Development Control
Ribble Valley Borough Council

Re: Planning Application 18/0786

Address: Dog and Partridge Hesketh Lane Chipping PR3 2TH

Description: Conversion of an existing restaurant (A3) to create twelve apartments (C3) and the siting of four holiday lets.

# PROPOSED BLOCK PLAN

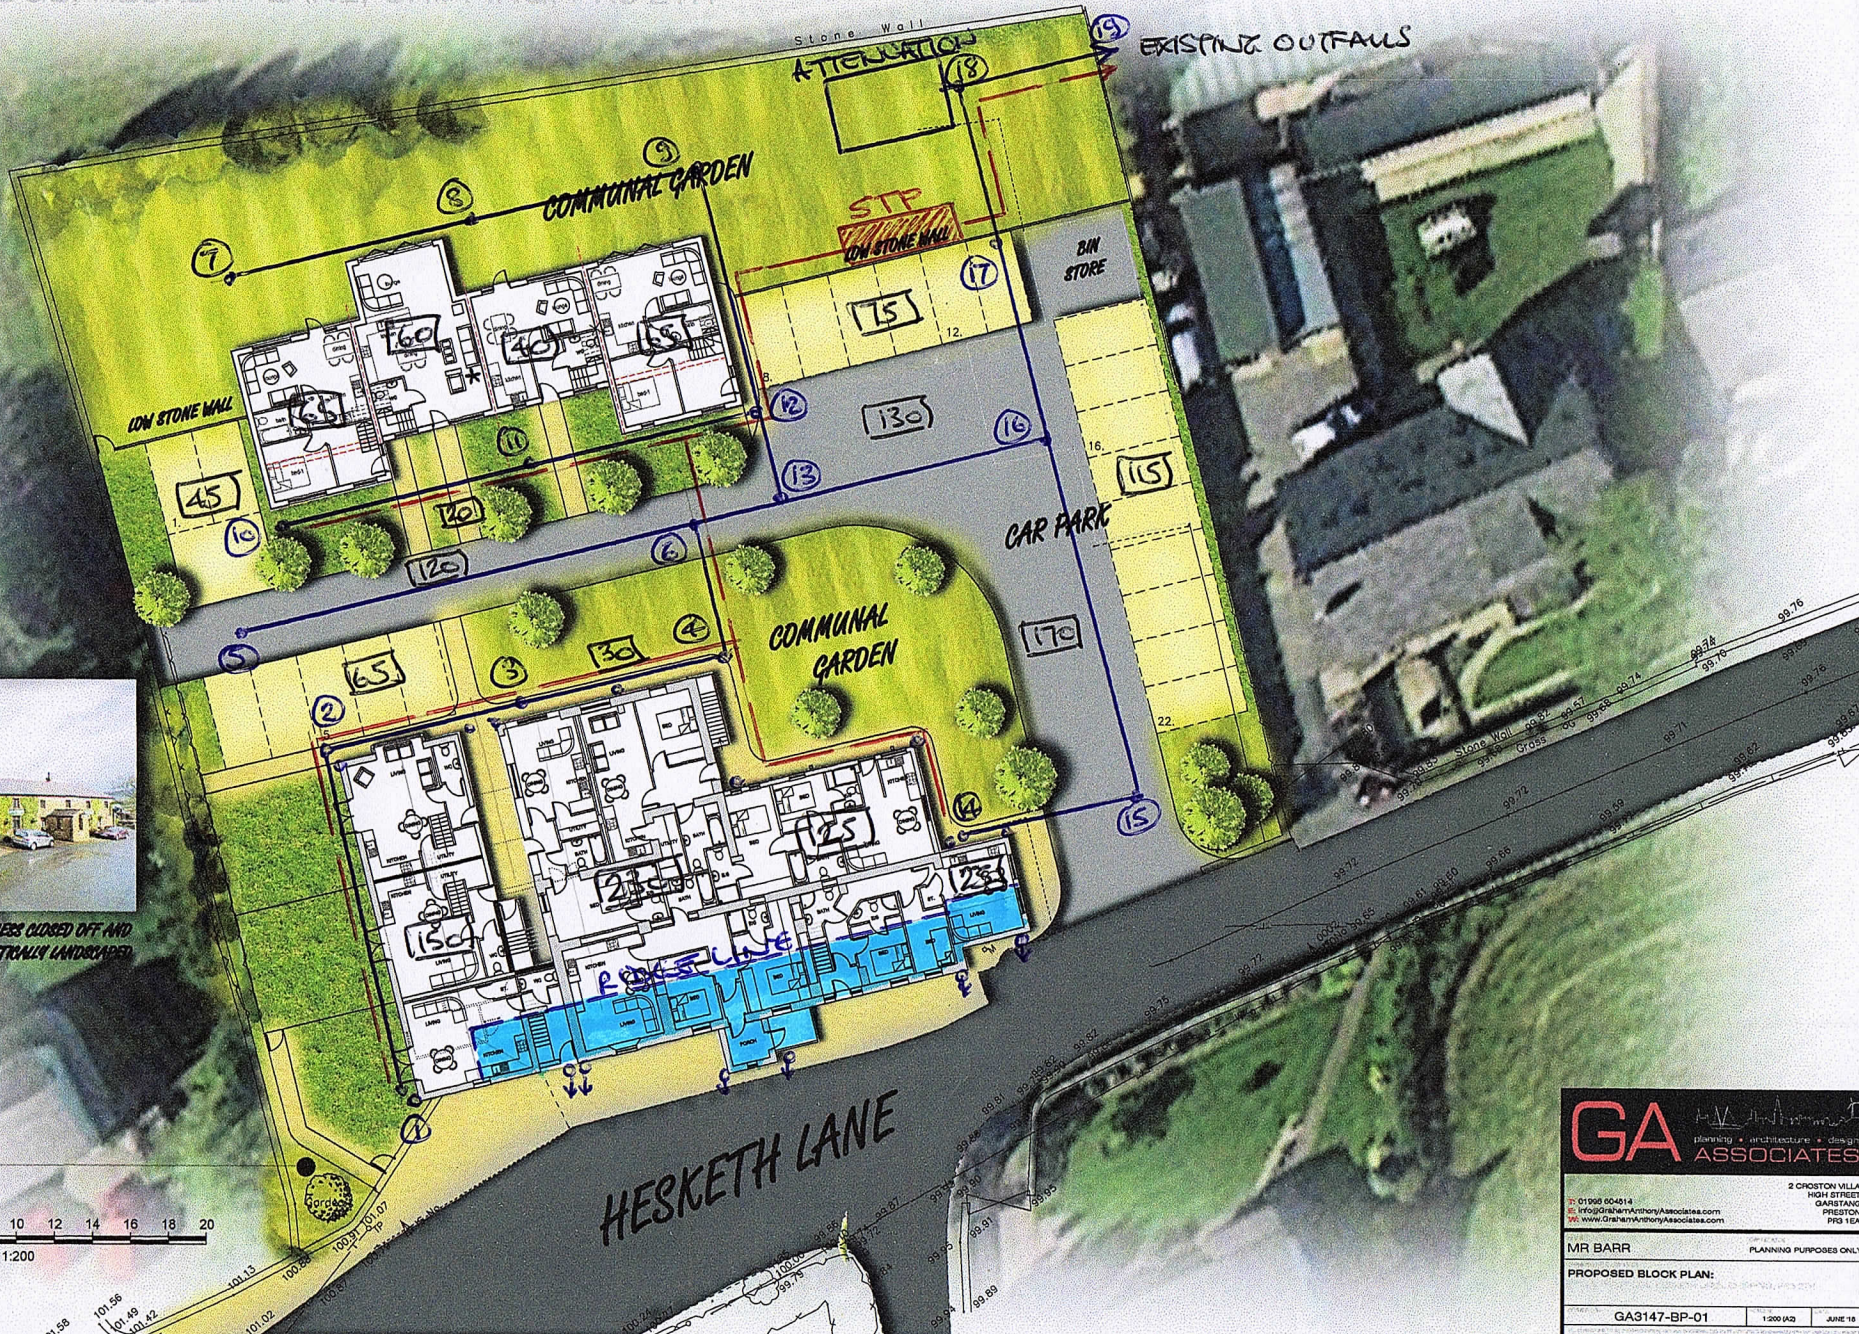
There are concerns regarding the pedestrian access along the frontage of the development from the car parking spaces to Apartments 3, 5, 6, 9 and 10. It is expected that a footway with a kerbed edge should be provided, partly to prevent additional parking which may lead to pedestrians having to walk in the carriageway.

Whilst a swept path analysis has ensured that the refuse collection vehicle can enter and leave the site in a forward gear, there is a concern regarding the functionality of car parking spaces 5 – 7, further swept paths are required to ensure their functionality. The Department of Transport's document Manual for Streets, Sections 8.3.50-2 gives guidance regarding the access to parking bays.

The positioning of the bin storage points are still of concern, according to the Manual for Streets Section 6.8.9 states that residents should not be expected to carry waste more than 30m to the storage point. Similarly, refuse collection vehicles should be able to get within 25m of the storage point. It may be a requirement that there are a number of bin storage points, rather than one central location, with some flats being served from the roadside frontage of the development.

There has been some provision for cycle storage, to both the residential complex and the holiday lets. It would be expected that the holiday lets would have sufficient covered cycle storage for 4 cycles to each let, with additional covered cycle storage being provided for the residential complex. Further evidence of the type of cycle

storage is required, racking with a canopy that is relatively open should not be used as cycles are not suited to being left exposed to the elements.
